From: Dave & Jane Benham [mailto:dave@benham.co.uk]
Sent: 18 February 2021 14:04
To: Nicola Moore
Subject: BR/34/21/PDH Clarification

DRAWING N° PR. 5 (raised)

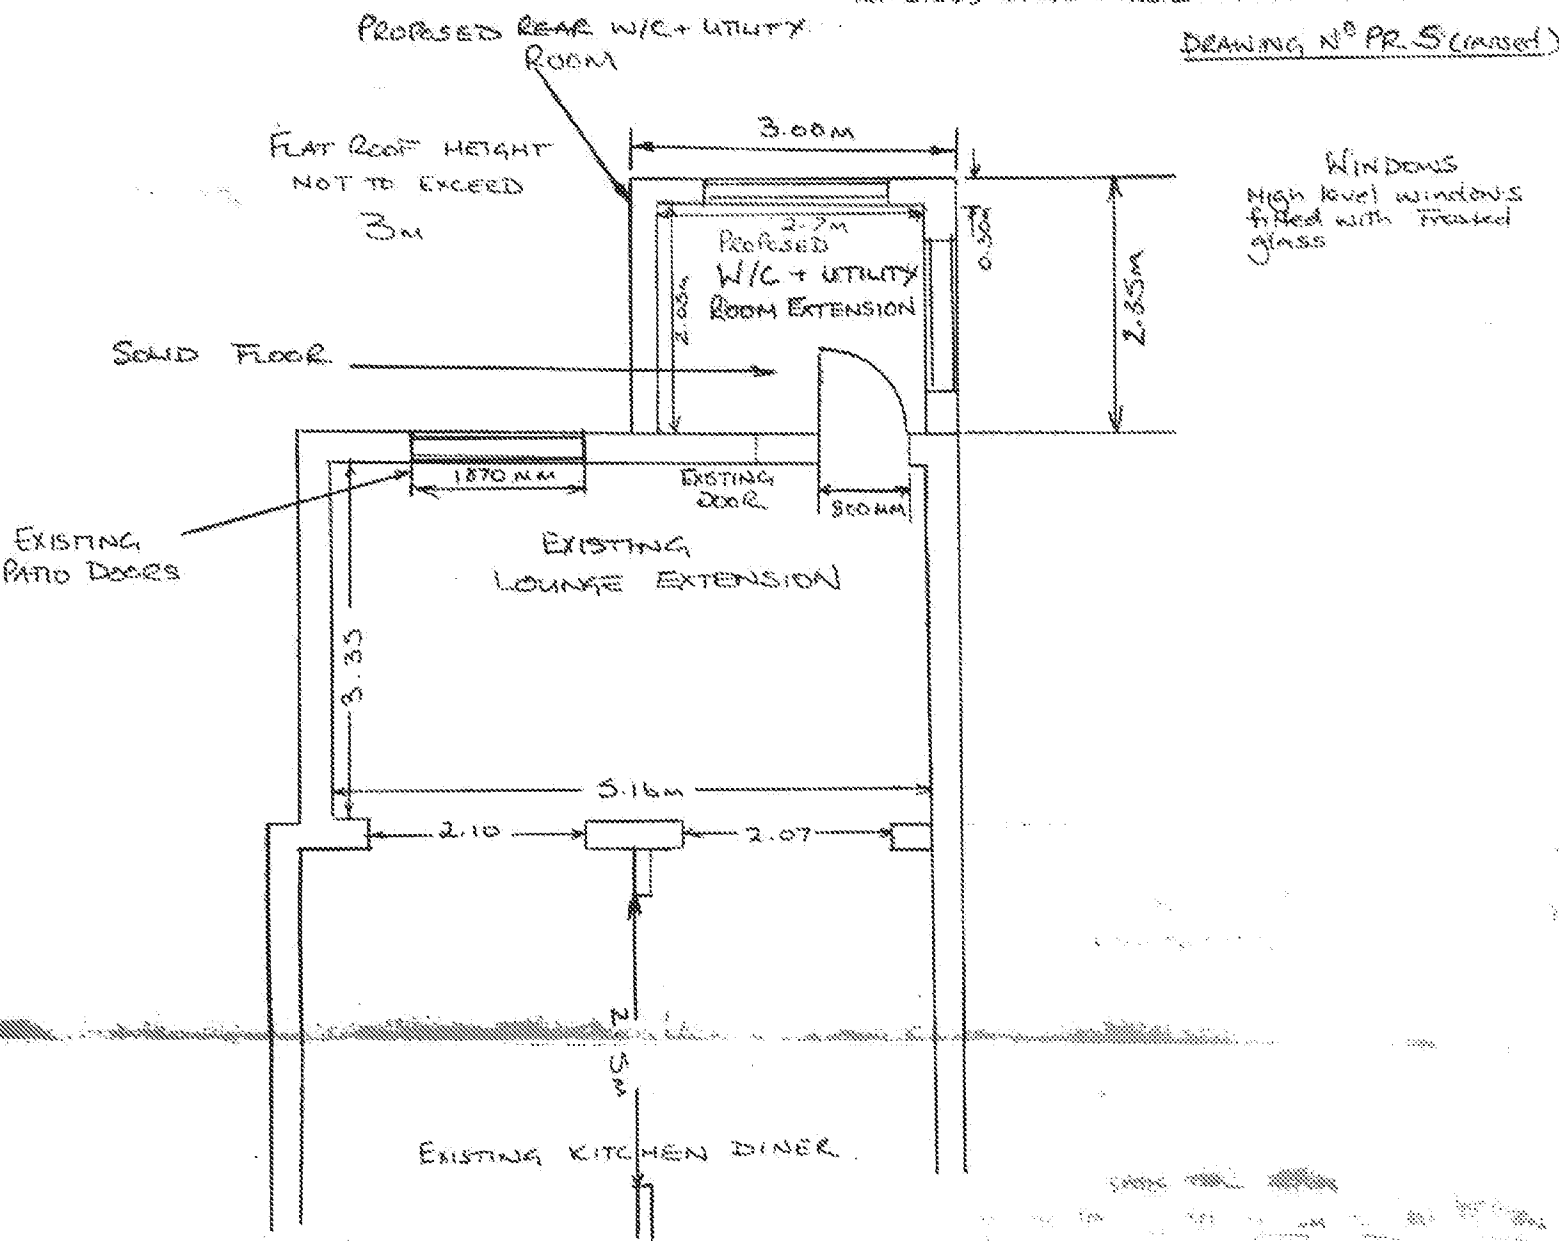
For clarity please confirm the proposed height and height of eaves as on the application form it says 4m for both, but on the floor plan it says flat roof not to exceed 3m.

The plan is the correct figure, the flat roof will not exceed 3m.
